**Consultation Response from Mike Hibbert,
KC Waste Strategy(Refuse & Recycling)**

2024/93156 Healey Lane Mills, Healey Lane, Healey, Batley, WF17 7SH

Outline application for redevelopment of existing Islamic Centre

Responding Ref: WPN 24-049

**DRAWING REF:** 21185-D02-A **REV:**

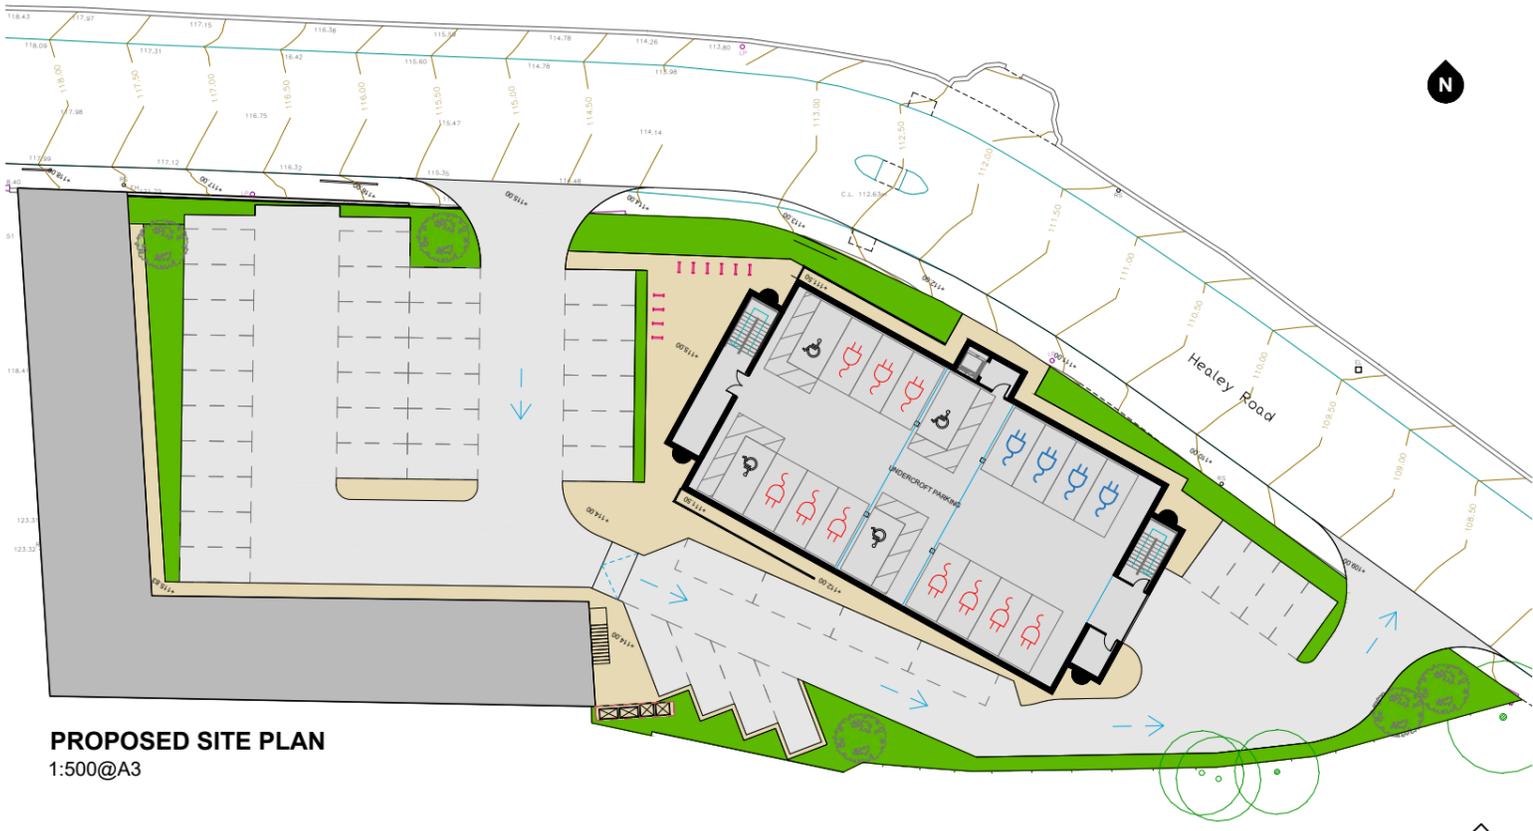
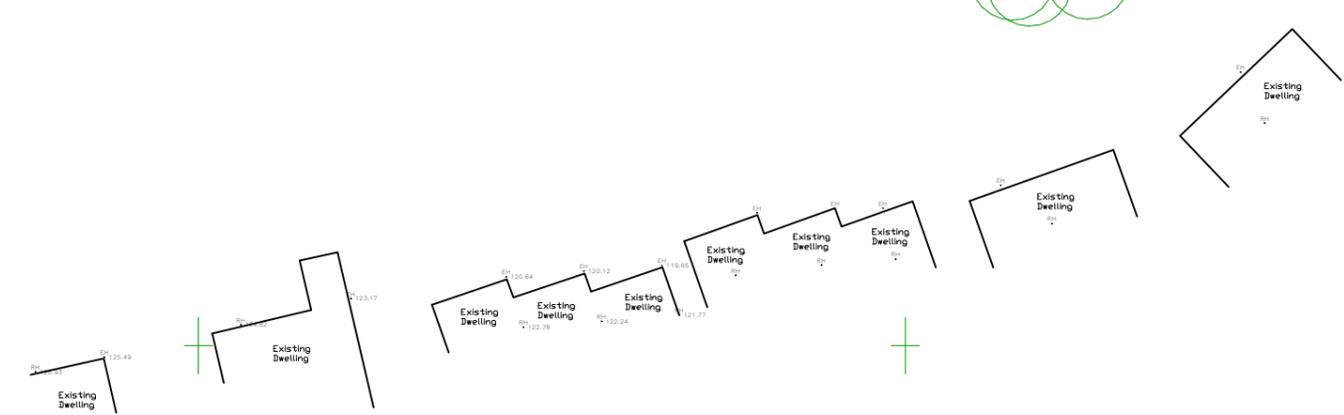
- Waste storage for the development is shown on Site Plan Drawing ref 20185-D02 Rev A dated 9/7/2023 that shows the proposed location of wheeliebin storage within the site.

- It is not clear as to the composition or quantity of waste that is expected to be generated on site. The Waste Strategy for England 2018 sets out targets to encourage minimising waste, promoting resource efficiency, and moving towards a circular economy. The Strategy will be implemented by the introduction of Simpler Recycling legislation that from March 2025 will require separate storage capacity for food waste from the kitchen area, recyclate such as glass, plastic, metals, packaging and card/paper in addition to residual wastes.

- The Healey Islamic Trust building currently on the site has a waste collection once a fortnight of 1x 1100ltrs wheeliebin. Future choice of wheeliebin containers and numbers will need to reflect the waste volumes generated. The dimensions of a 1100ltrs Wheeliebin is 1375x990 (floor space 1575x1190). There also needs to be space within the store to enable access to bins by residents and collection staff for servicing

- Wheeliebins should be screened or contained within a purpose designed store. Details of bin store construction can be found in the Kirklees Waste Management Design Guide 2020.

- The waste store should be secure to prevent theft, unauthorised use/ fly tipping or rough sleeping. If the doors to the bin store are to have a keypad to secure access these details will be required by the collection staff.

- It is not clear from the proposal the location of the Bin Collection Point (BCP) within the car park. The carpark may need to be marked to ensure parked cars do not block the Bin Collection Point.

- The route between the store and bin collection point needs to be a hard smooth surface, have a drop kerb and a maximum gradient of 1:12. Guidance indicates that the maximum drag out distance for a full 1100ltr wheeliebin should be in the region of 15m.

Additional information is required detailing waste storage, containers, capacity and design of the waste storage compound including, screening, surfacing and security

APPENDIX BGH 10

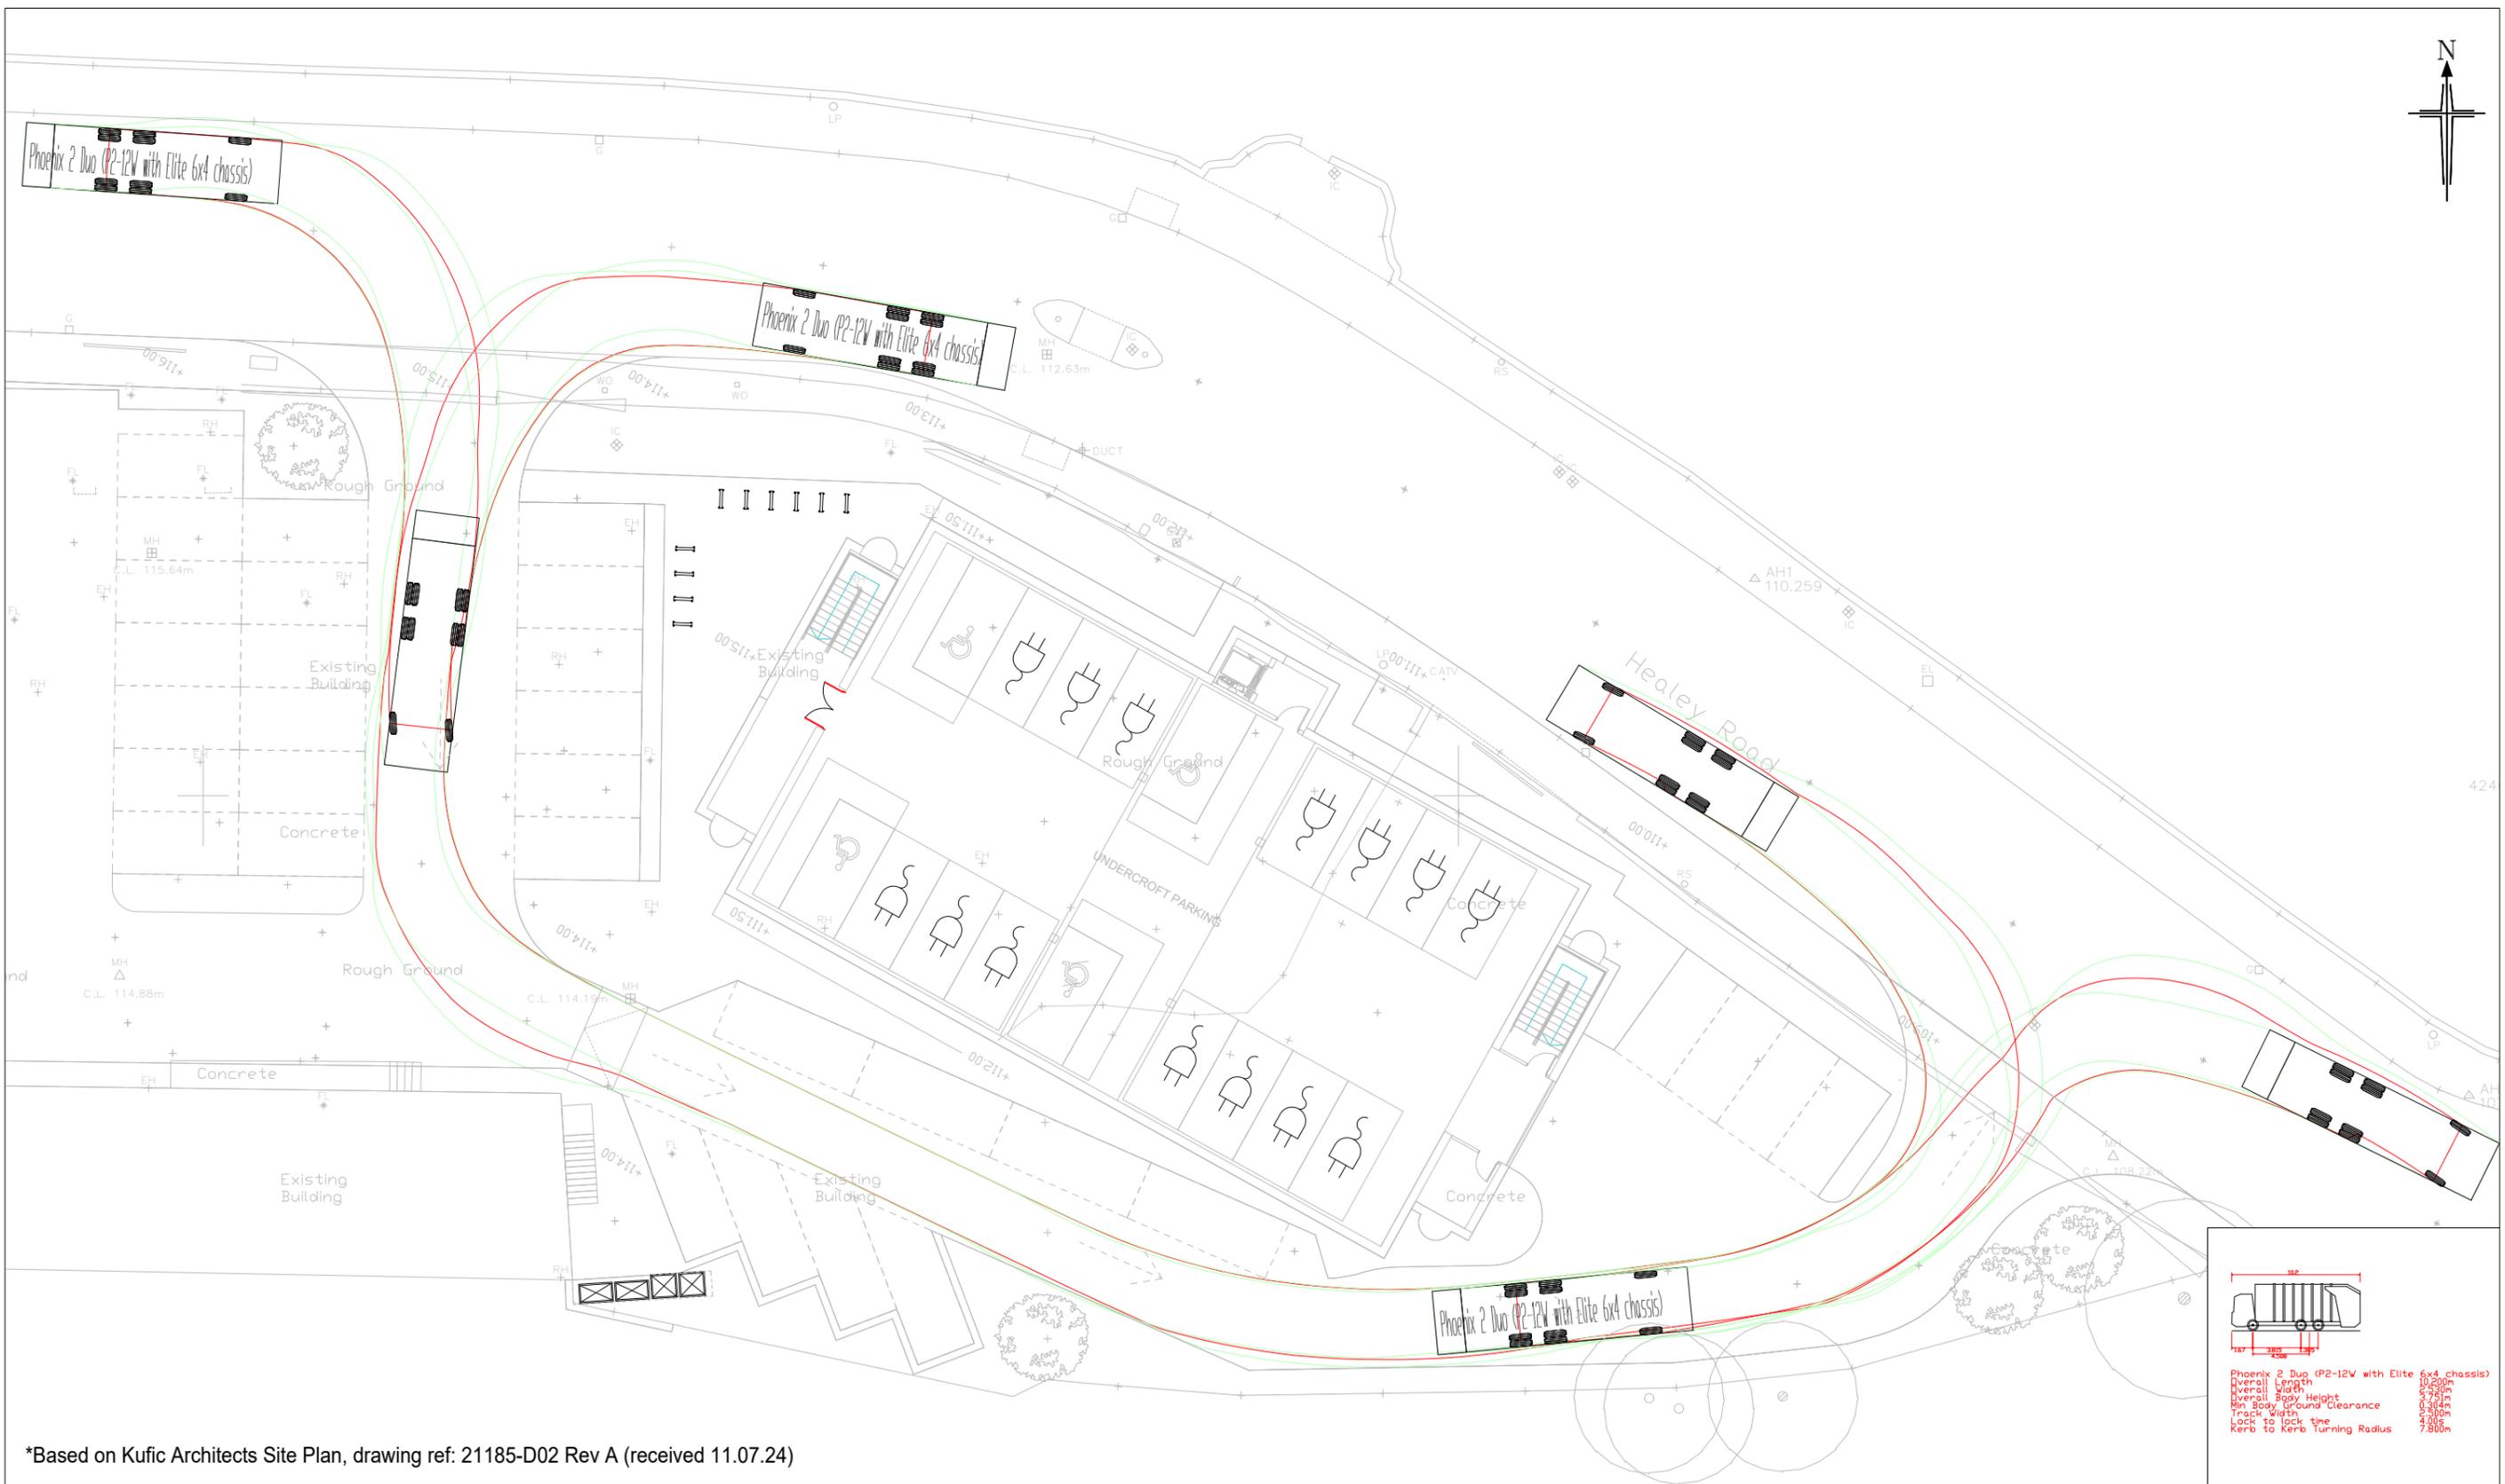
- The swept path analysis of Refuse vehicle Drawing No: 21/382/ATR/002 dated 16.07.2024 models a Phoenix 2 Duo 10.2m long RCV whereas the Kirklees standard RCV as set out in the Kirklees Waste Management Design Guide 2020 is 11.22m long.
